From: Louise Crane
Sent: 08 September 2017 13:28
To: Planning.Responses
Subject: FW: Planning Consultation on: BR/220/17/PL

APPLICATION **BR/220/17/PL**

Site Address: Central House 18 Waterloo Square Bognor Regis PO21 1SU

Description of Works: Change of use of first & second floors to form 2 No. dwellings & reversion of ground floor area to retail use. This application affects the character & appearance of The Steyne, Bognor Conservation Area.

## PROPOSED FLOOR PLANS

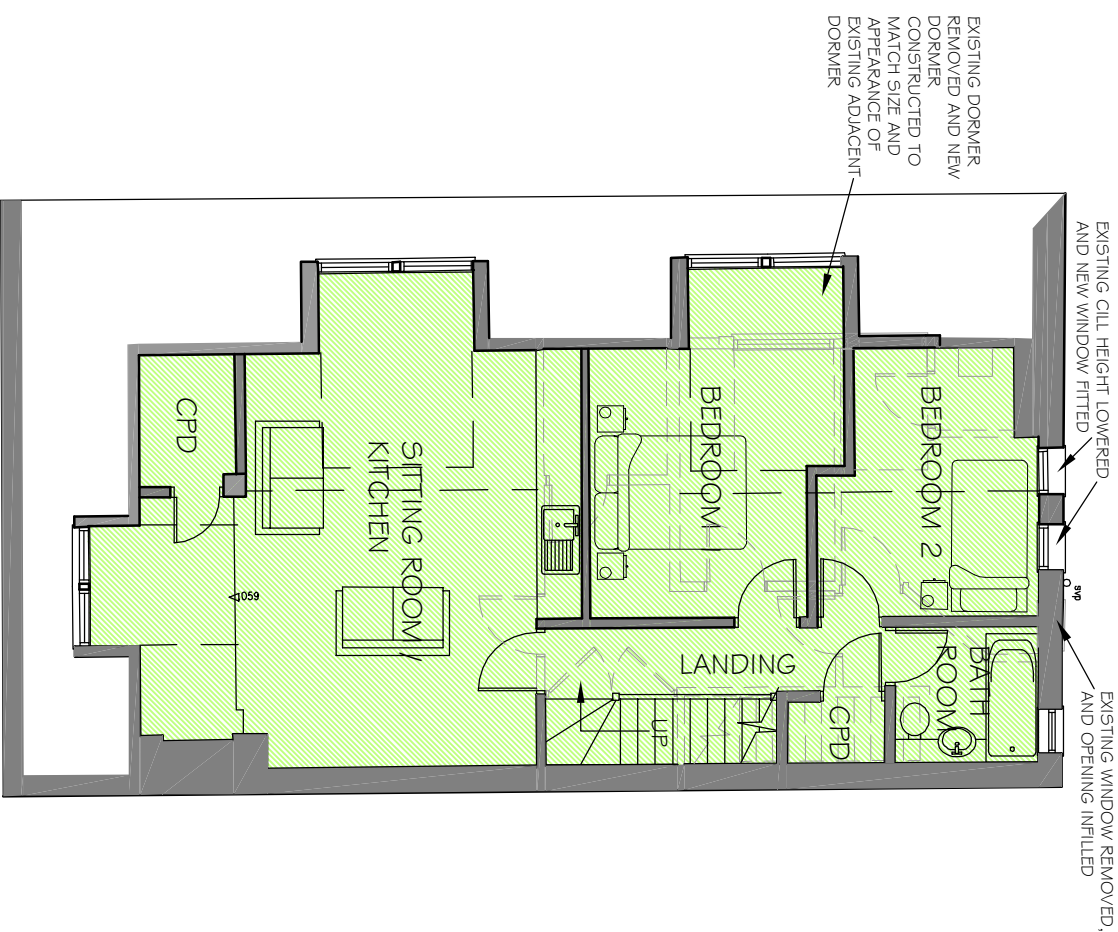
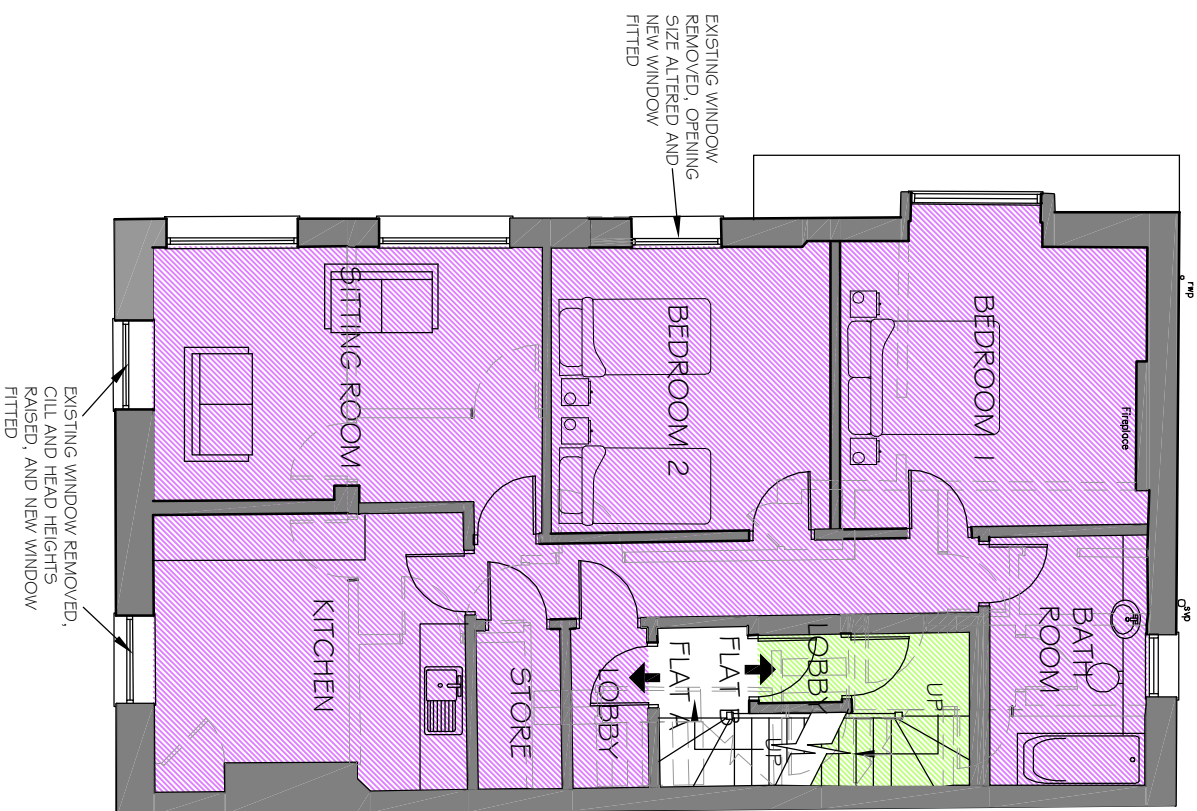
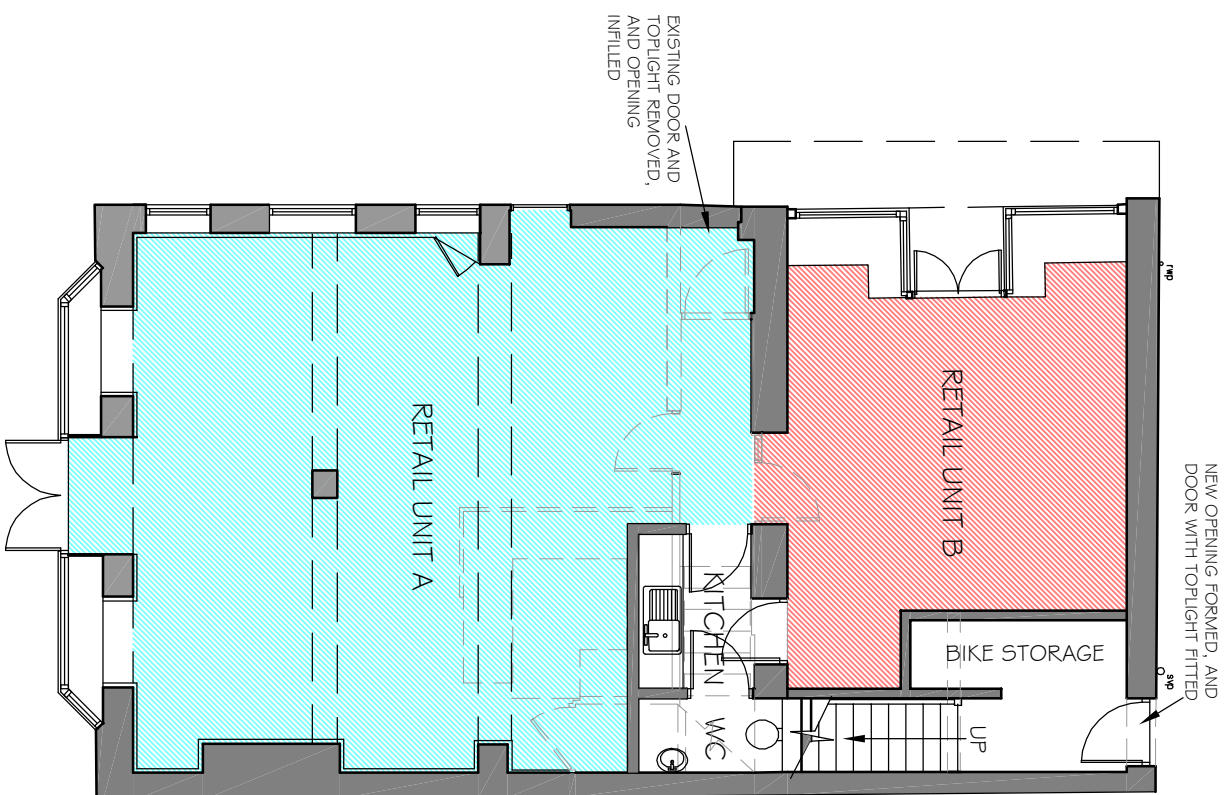
- Appropriate fire precaution facilities and equipment must be provided of such type, number and location as are considered necessary. Guidance on fire safety is contained in the LACORS guidance document – "Housing – Fire Safety, Guidance on fire safety precautions for certain types of existing housing"
- There should be adequate fire separation between the commercial unit on the ground floor and the residential flats above.

- Room sizes should meet the minimum standards for houses in multiple occupation if the flats are intended to be rented.
